**RE: AGRA BUILDING (C17-D13F). ENGINEER'S CERTIFICATION FOR
CERTIFICATE OF OCCUPANCY APPROVAL. ENGINEER'S STAMPED DATED
MARCH 12, 1998.**

RE: DRAINAGE & GRADING PLAN FOR AGRA BUILDING, (G-17/D13E)
RECEIVED JUNE 2, 1997 FOR BUILDING PERMIT
ENGINEER'S STAMP DATED 5-30-97

Drainage and Grading Plan

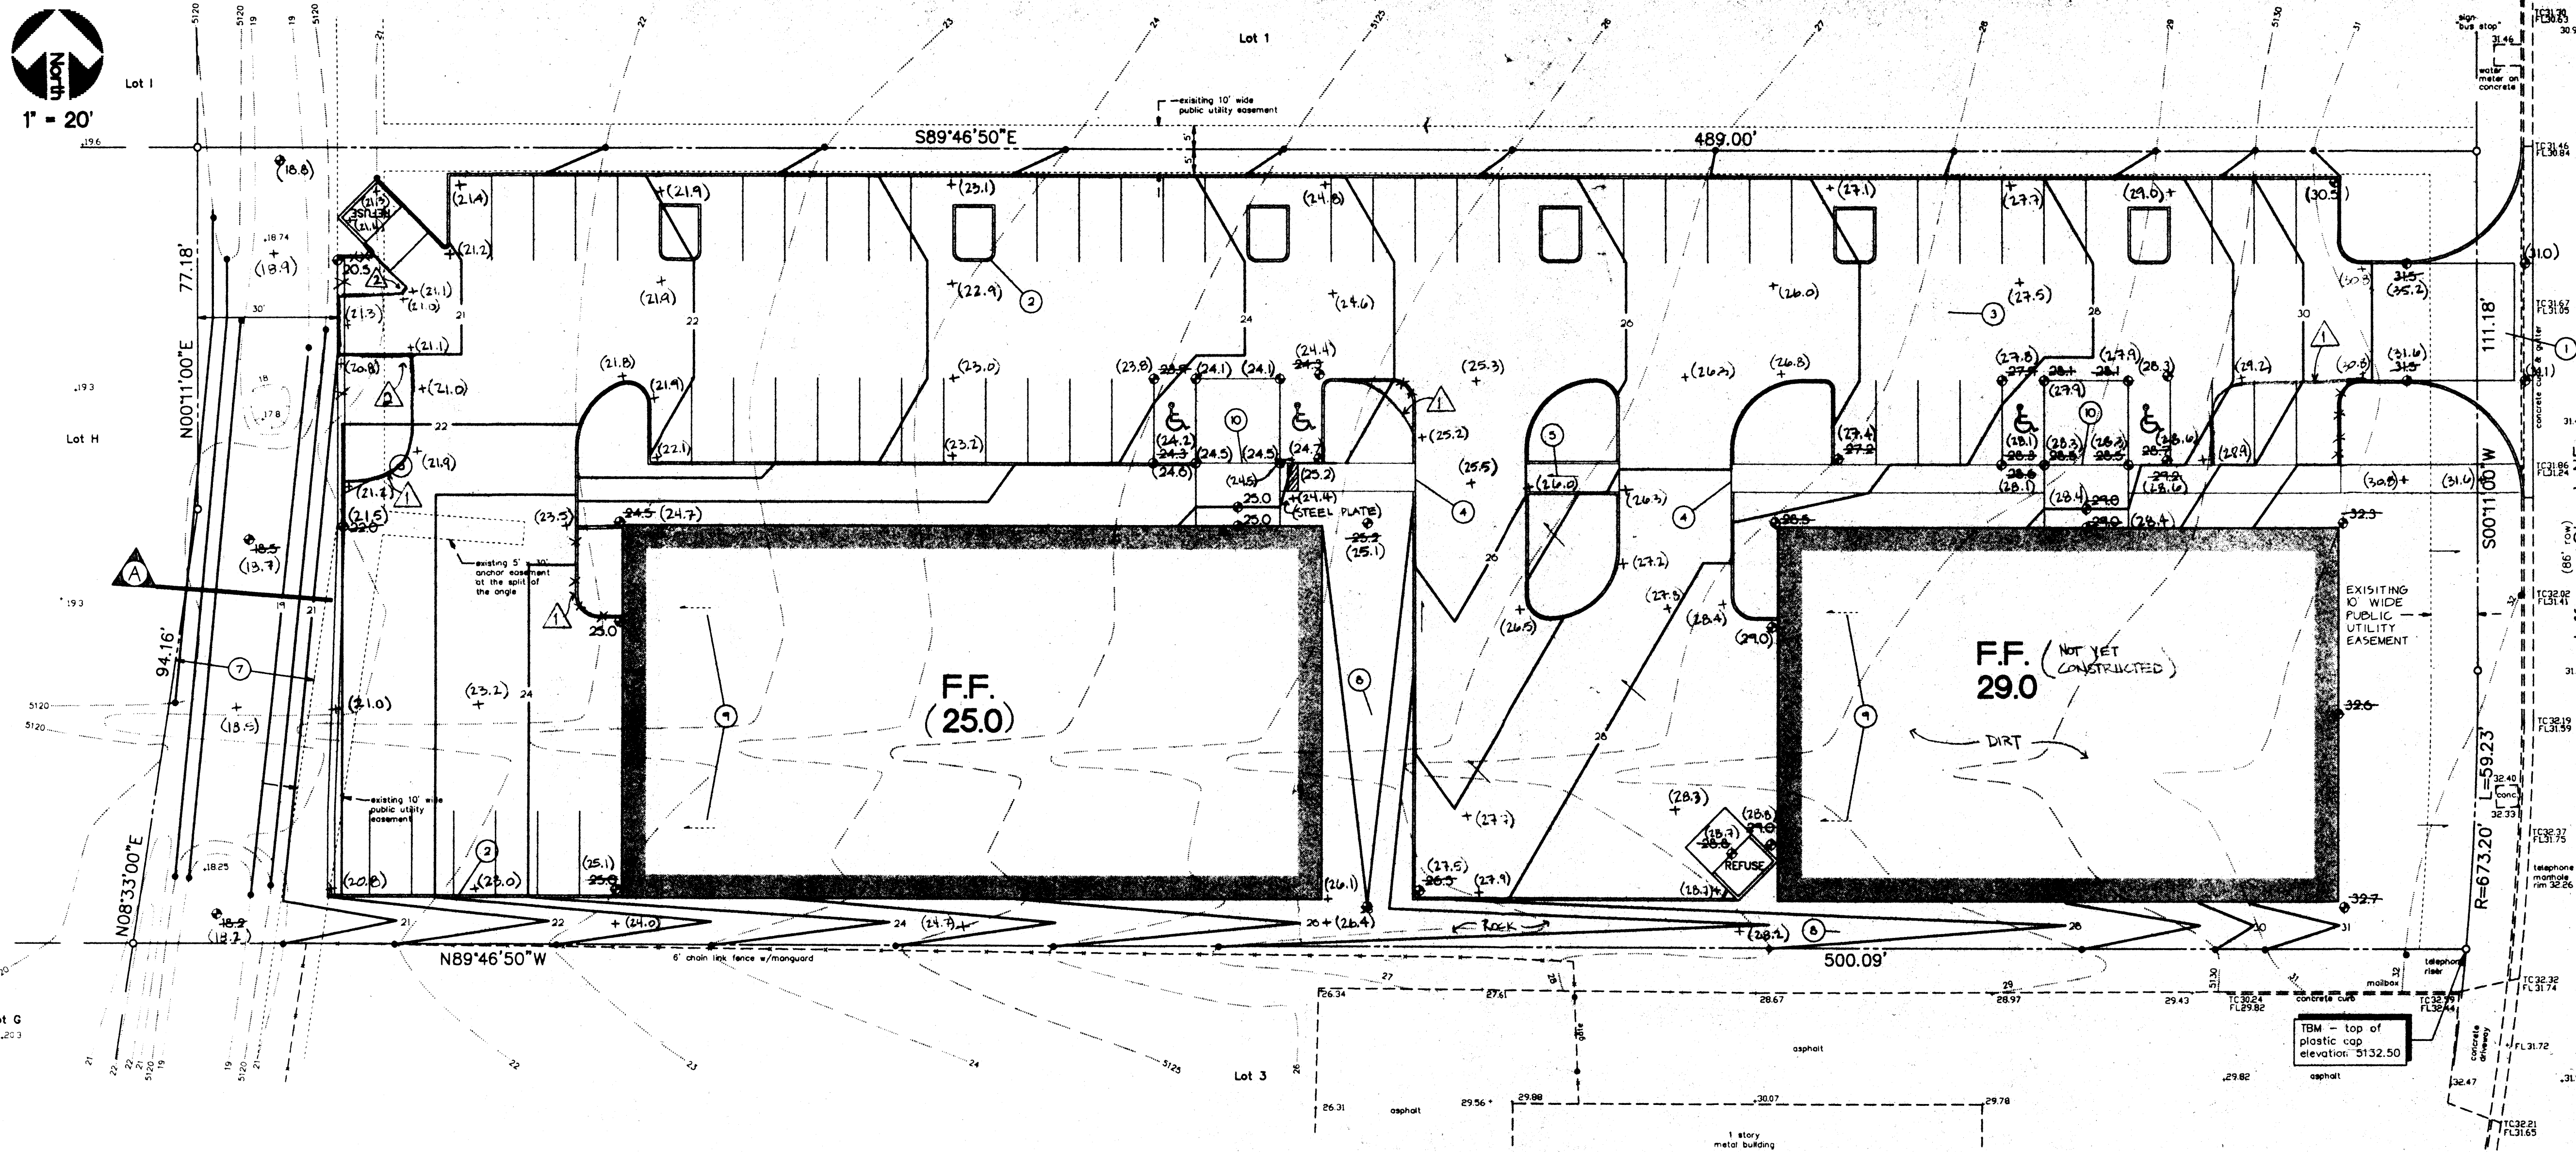
Plate 20 indicates that the earthen channel which drains Lots 1-11 (area = 16.2 ac) has a capacity of 76 cfs. This would prorate to an allowable discharge of 4.6 cfs/ac and 8.8 cfs for this site. The private channel accepts off-site flow from Lot 1.

Include a copy of the Drainage & Grading Plan dated 5-30-97 in the set of construction documents that will be submitted to Code Administration for the Building Permit. Engineer's Certification of grading & drainage per DPM checklist must be accepted by City Hydrology before any Certificate of Occupancy will be released.
